Submission on SSD-97528708 - Mixed-use development with in-fill affordable housing at 160 Oxford Street, Paddington

I am writing to object to State Significant Development Application 97528708 for development of 160 Oxford Street, Paddington and nearby properties.

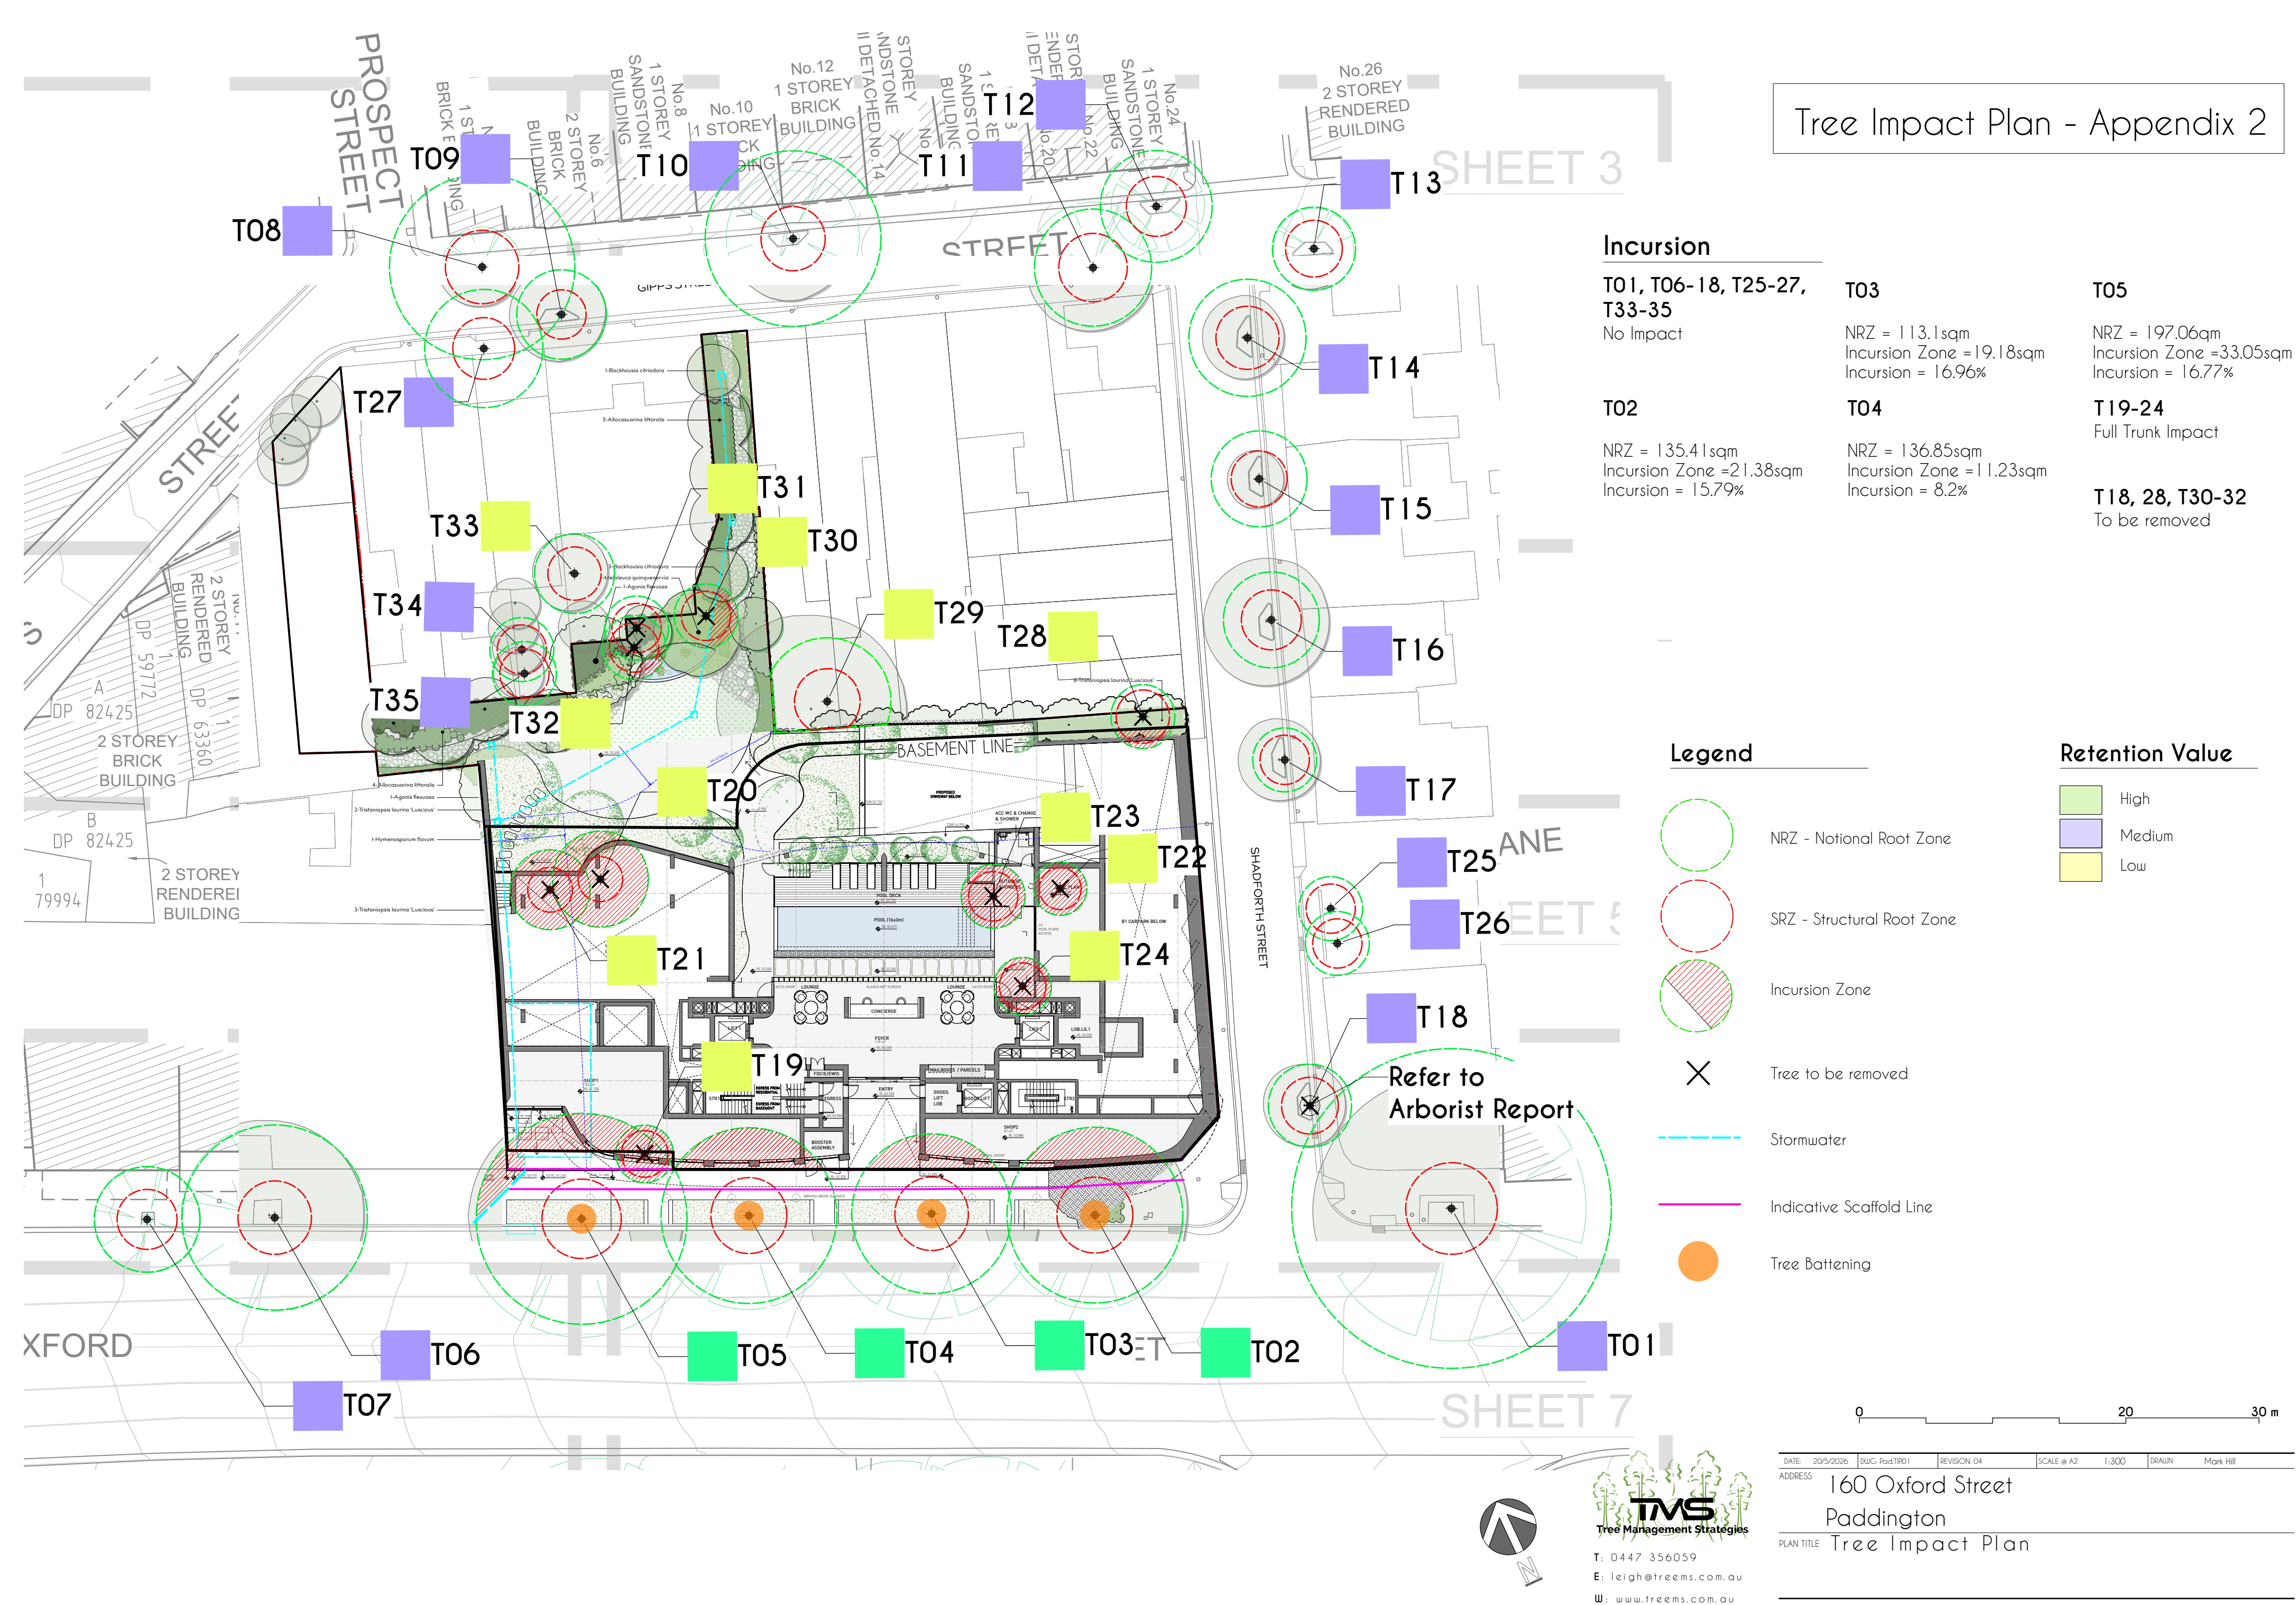
Excavation of the site presents real risks to the root systems required to support the trees in Oxford Street. These trees have taken decades to reach their current height and breadth. They represent a fundamental element in the Oxford Street streetscape.
